Application for Removal or Variation of a Condition following Grant of Planning Permission or
 Listed Building Consent

New bespoke Eco-Home to rear/side of existing Nateby Crossing Cottage, with associated driveway improvements and removal of rear extension and outbuilding.

22/00425/FUL

2412-P02      Revision: A      Scale: 1:100 @ A3      Date: MAR. 24'

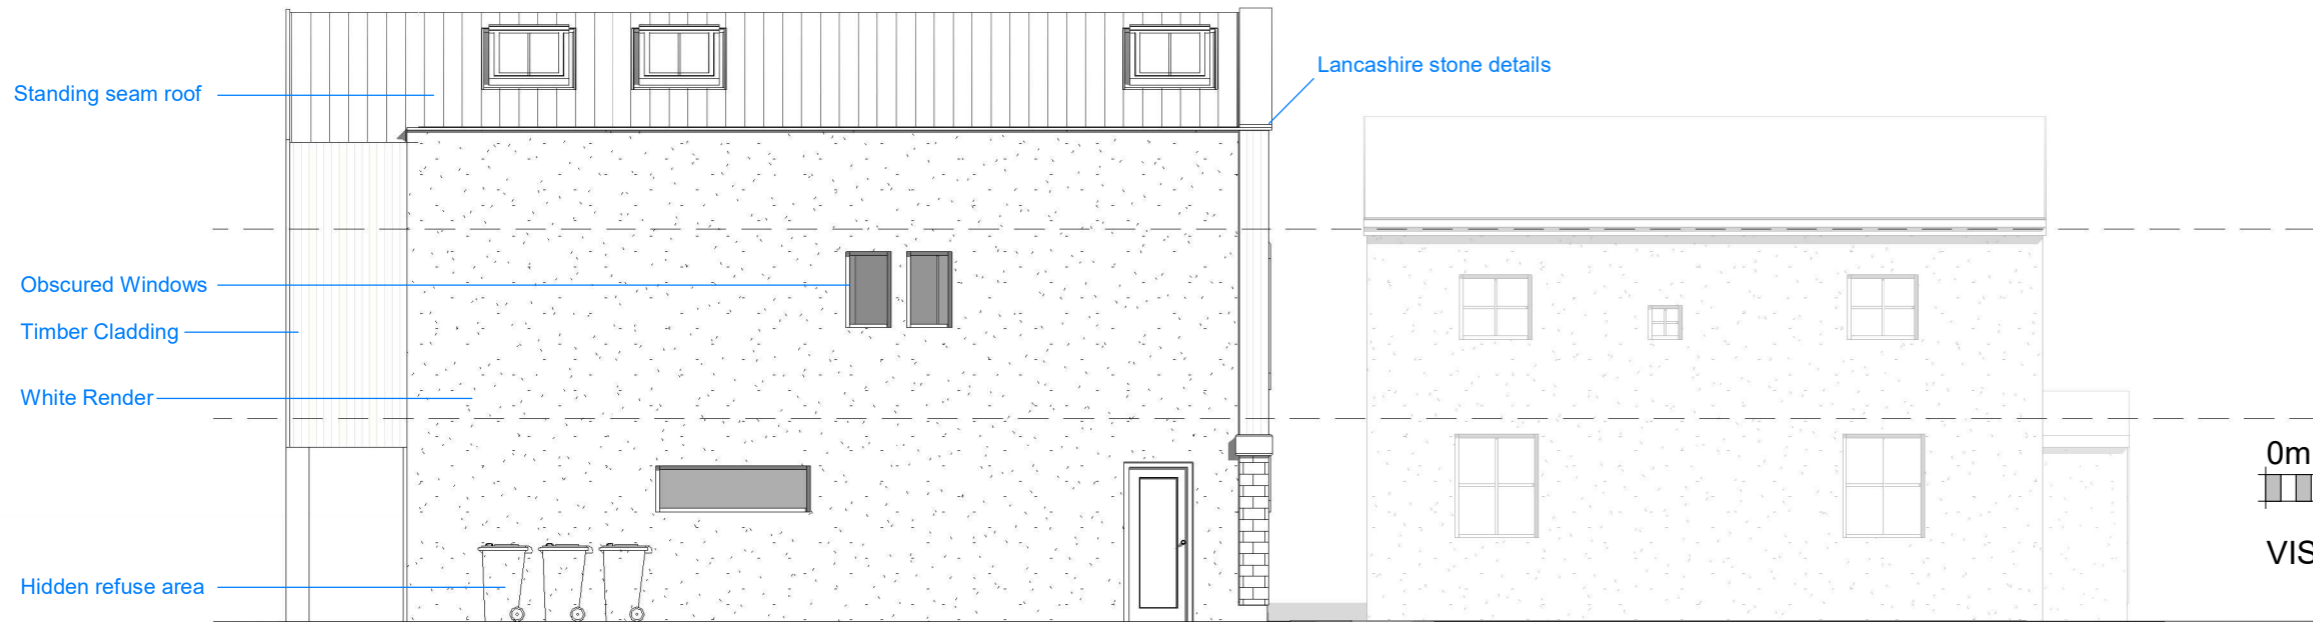
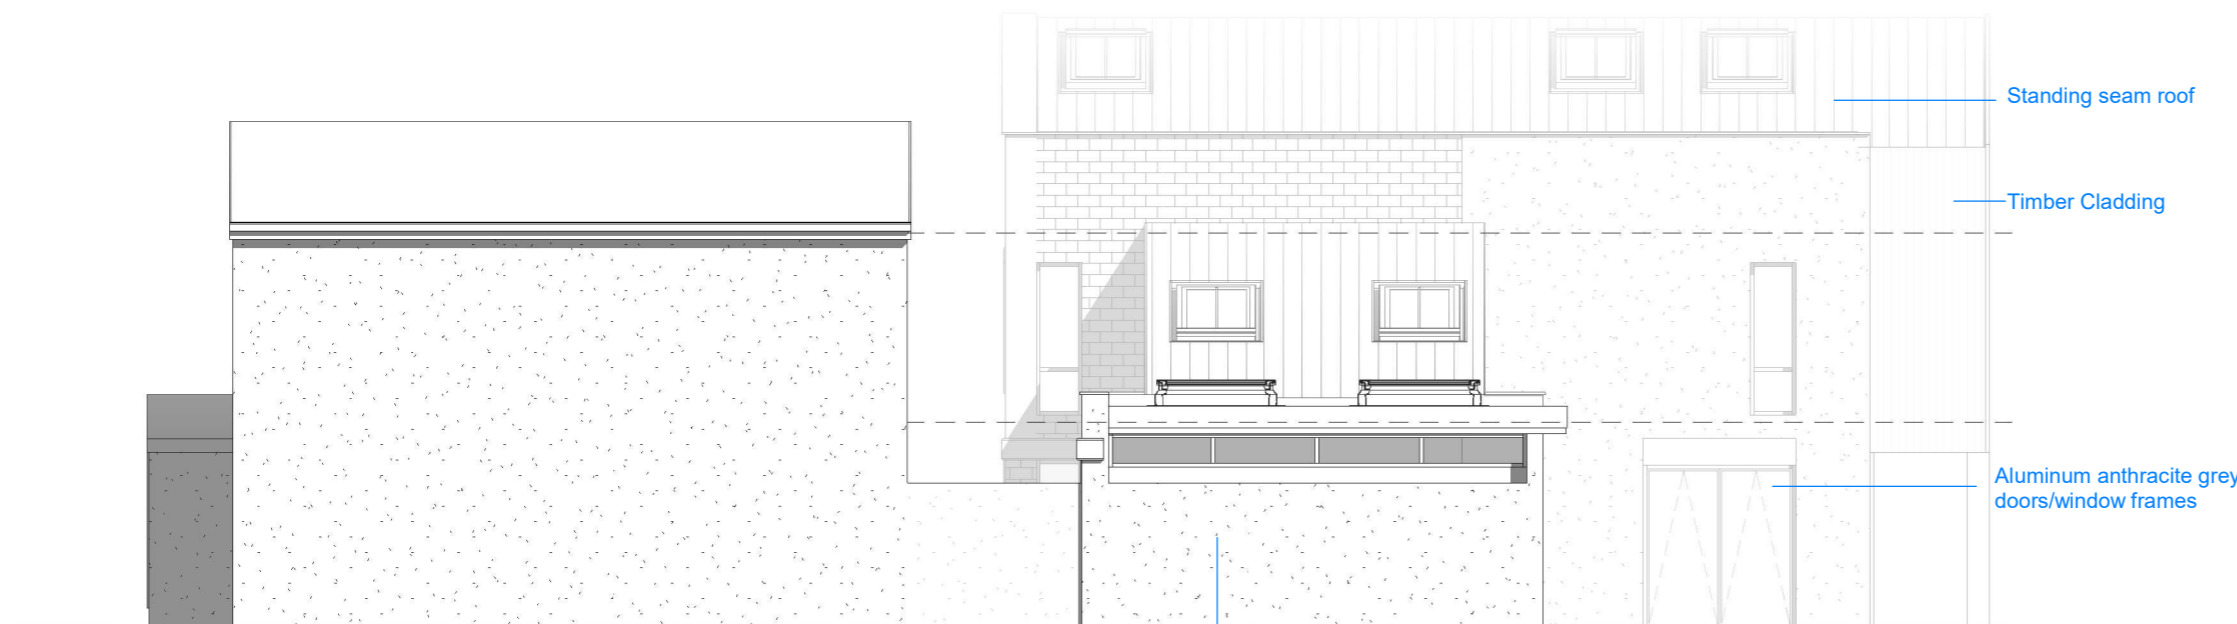
To incorporate the following revisions to the design;
Omit brise soleil system to balcony and replace with timber cladding walls with aluminium trim to rear facade.
Front elevation - Replace Lancashire stone with vertical timber cladding finish (larch / cedar / composite), above first floor level.
Front elevation - Reduced fenestration, refer to '2412-P02'.
Chimneys are omitted.

Replace the approved drawings to reflect the design changes (as above).
